Remodelling & extensions
Hascombe 33 Tamarisk Way East Preston

Thank you for your internet representation made on 21st October 2015 which has been recorded as '**an objection**' with the comments as follows:

title Proposed Elevations

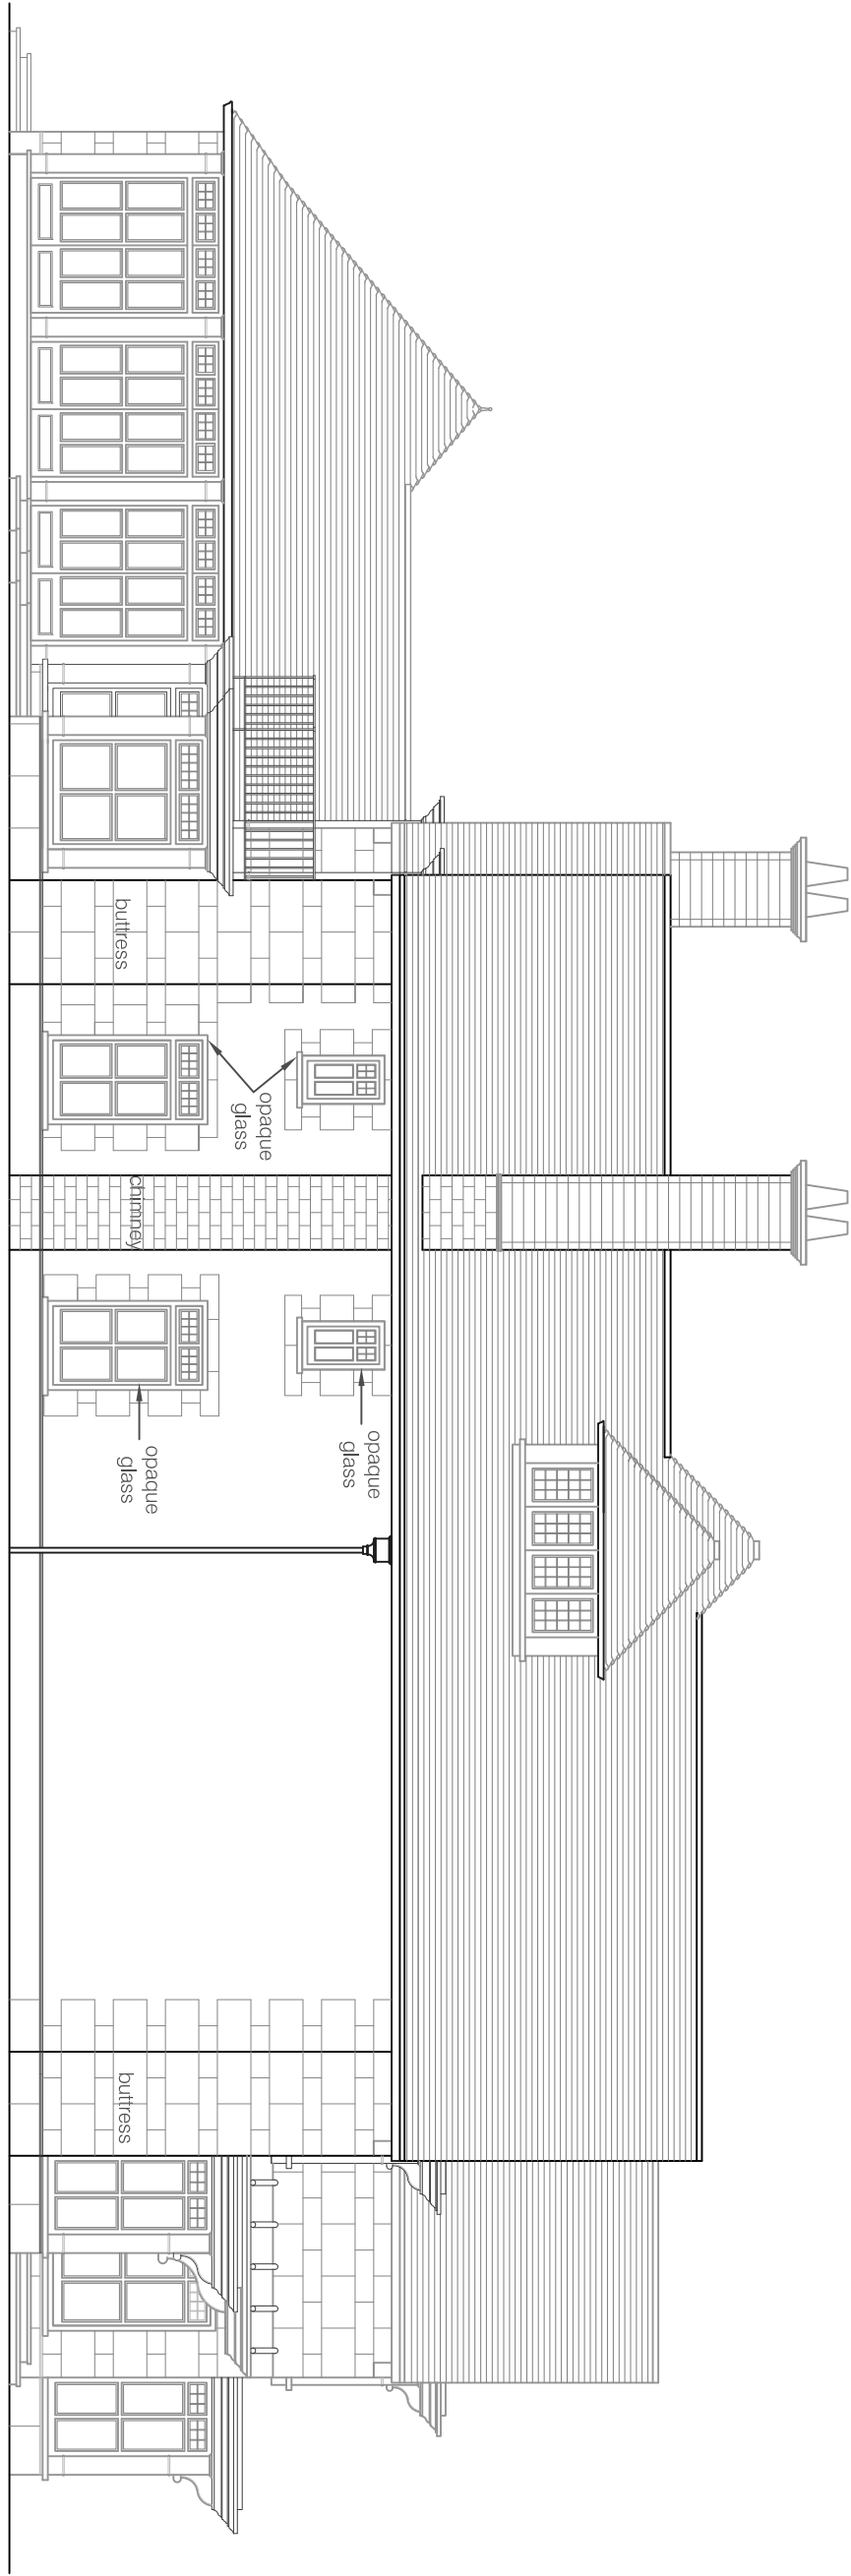
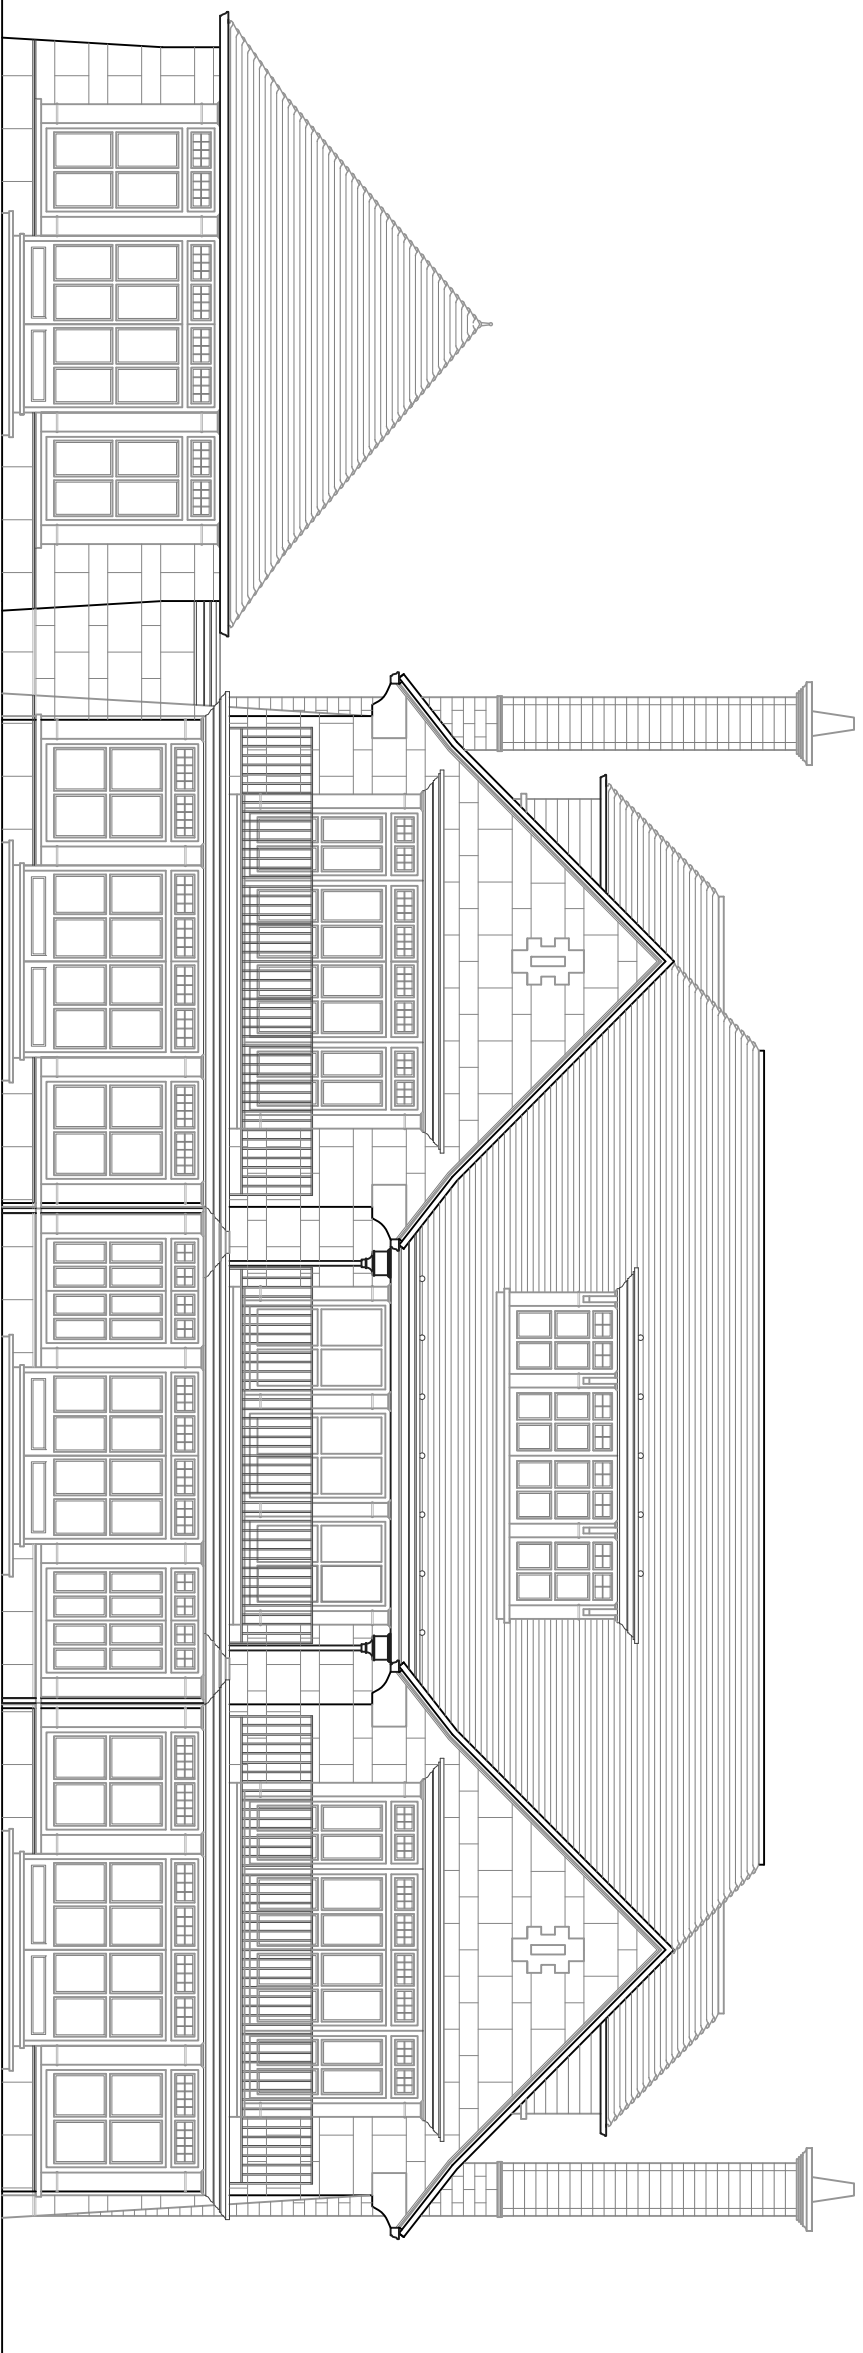
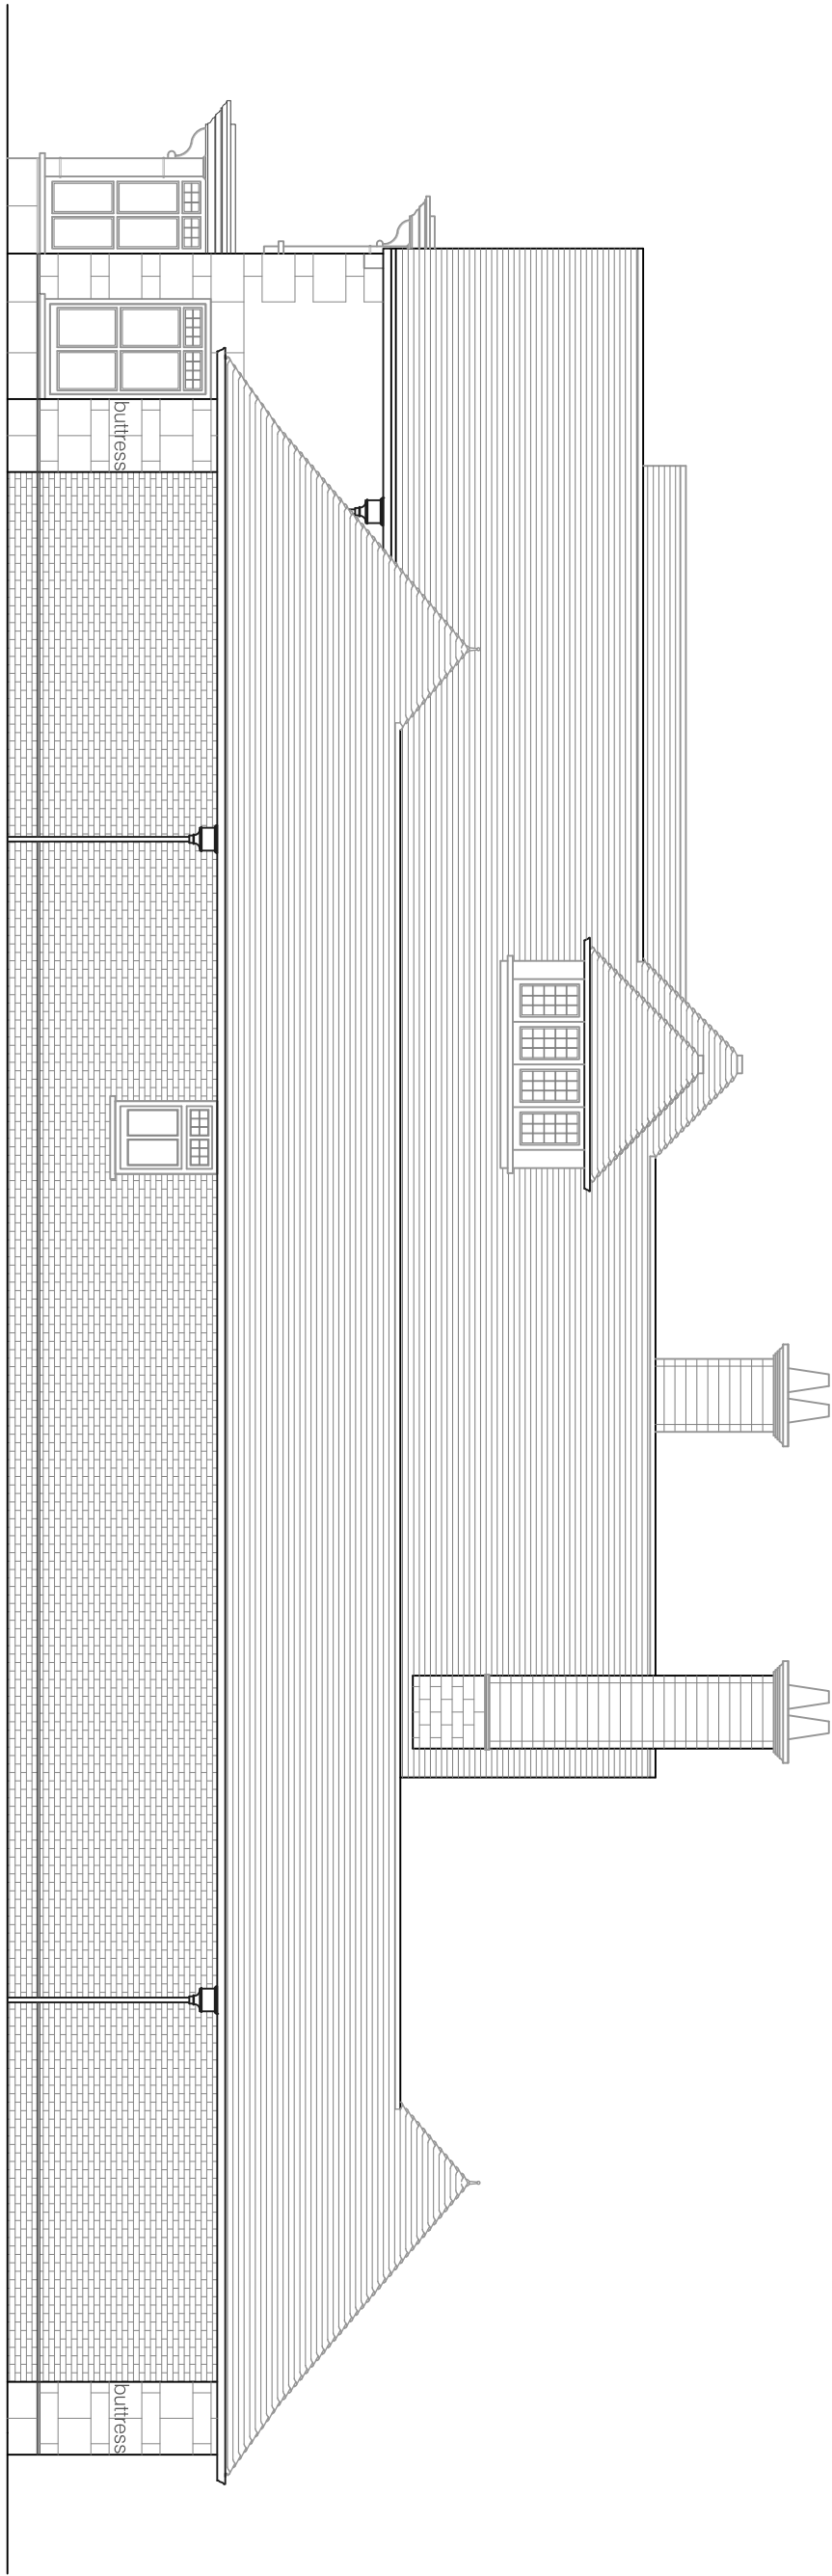
Whilst the North and South elevations greatly improve the look of the property, the proposed increase in both footprint and volume of accommodation is disproportionate; No. 33 is already, a very large house by any measure. This section of Tamarisk Way contains substantial houses which have been planned to sit comfortably within their plots, affording residents privacy, and no loss of enjoyment due to over-proximate buildings. I suggest that the proposed development of 33 Tamarisk Way - in particular the very long Southerly extension on the West side of the plot, will have a considerable negative impact on this section of the road, and upon neighbours' enjoyment of the location.
